RE: 20250611_CMCC SSD8989 Modification 5_Request for Additional Information

Regarding MOD5 and tree planting as outlined below, Biosis notes the following:

L02

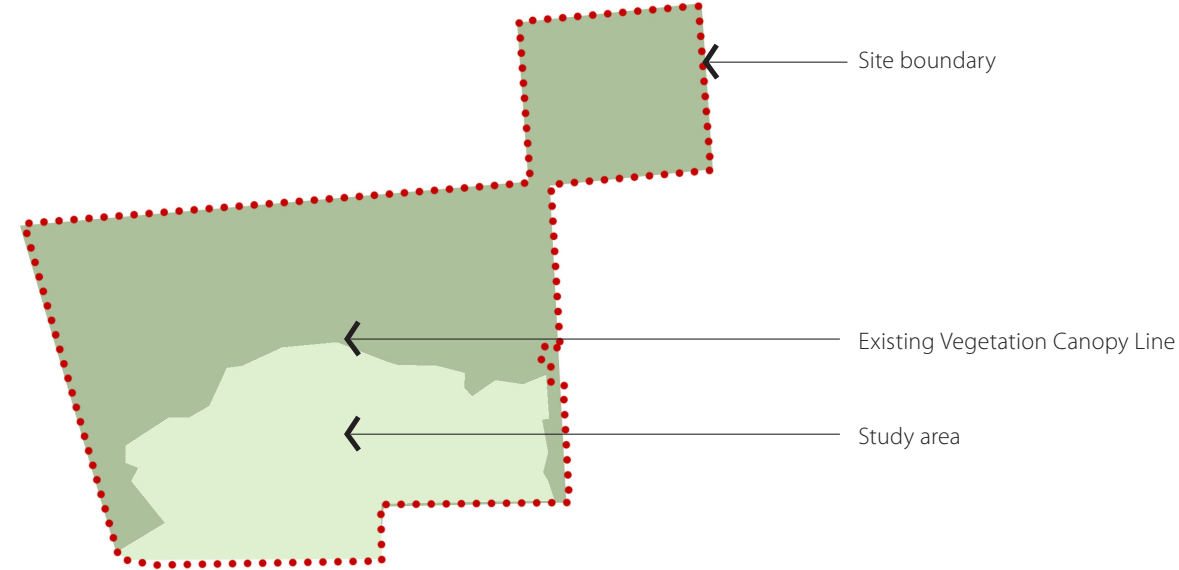
- Tree 36 is located within the development footprint boundary of the Approved BDAR (Biosis 2018) that accompanied the EIS (de Witt Consulting 2018).
- Tree 36 is located within Plant Community Type (PCT) 1564 Blackbutt - Rough-barked Apple - Turpentine - ferny tall open forest of the Central Coast of the Legacy PCTs assigned during the Approved BDAR phase (Figure 4; Appendix 2 of Biosis (2018)). This PCT is now mapped as PCT 3544 Coastal Sands Apple-Blackbutt Forest per the Mod-5 BDAR (Biosis 2025) and revised PCT classifications in NSW (DPE 2022).

- Primary canopy species for PCT 3544 are Blackbutt *Eucalyptus pilularis* and Smooth-barked Apple *Angophora costata*, occasionally with Red Bloodwood *Corymbia gummifera*. Other Eucalyptus and Corymbia species may be present but in low abundance.

- Port Stephens is within the Central Coast Koala Management area as defined by Schedule 2 of the Biodiversity and Conservation SEPP.
- Each of the primary canopy species for PCT 3544 (Blackbutt, Smooth-barked Apple and Red Bloodwood) are listed Koala use tree species as per Schedule 3 of the Biodiversity and Conservation SEPP.

- Council's *Biodiversity Technical Specification 2024* requires native trees with a height greater than 3 m and diameter greater than 300 mm (measured 1.3 m from the ground) to be replaced at a ratio of 1:2.

- Ideally, removal of Koala habitat trees should be of the same species, sourced from local provenance seed stock, planted in a cluster and, where feasible, in the vicinity of any retained food trees, protected, nurtured and maintained until the trees have reached maturity.

- Tree 36 was a Smooth-barked Apple *Angophora costata*.
- Replacement with **one Smooth-barked Apple** and either **one Blackbutt or one Red Bloodwood** would be considered suitable.
